# Submission on Development Application SSD 6882

By Mark Rowe, Narimba, Narrandera NSW 2700

26<sup>th</sup> June 2015

I have some comments about the proposed ProTen Euroley poultry production complex as follows:

FIGURE SK02

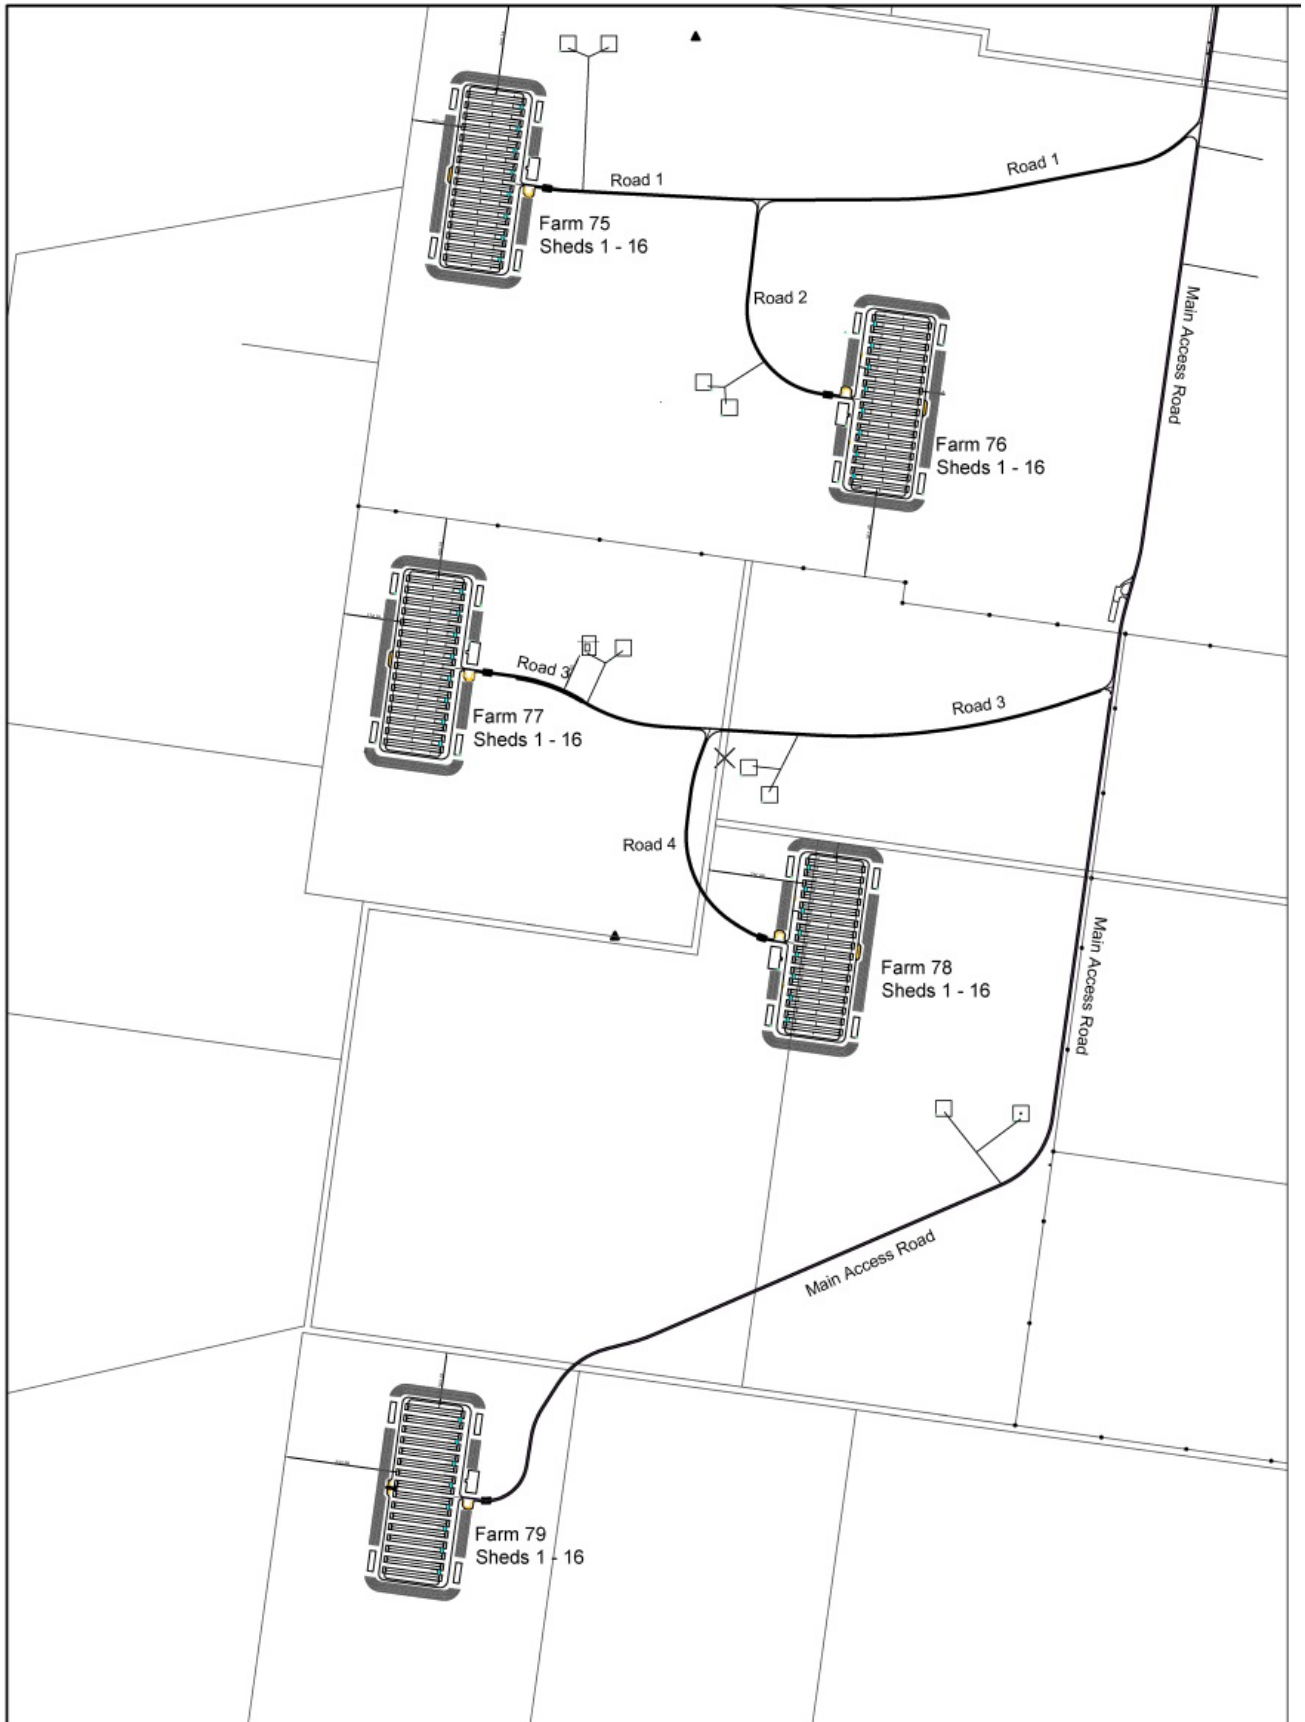
The proposed intersection on the Sturt Highway appears to be in quite a dangerous location, situated in a depression between two small rises.

From a safety perspective, a much better option would surely be to use Mundara Road which also has frontage to the proposed complex. This intersection has excellent visibility in both directions.

If the proposed intersection site is to proceed then turning lanes would be essential to help alleviate some of the risk.
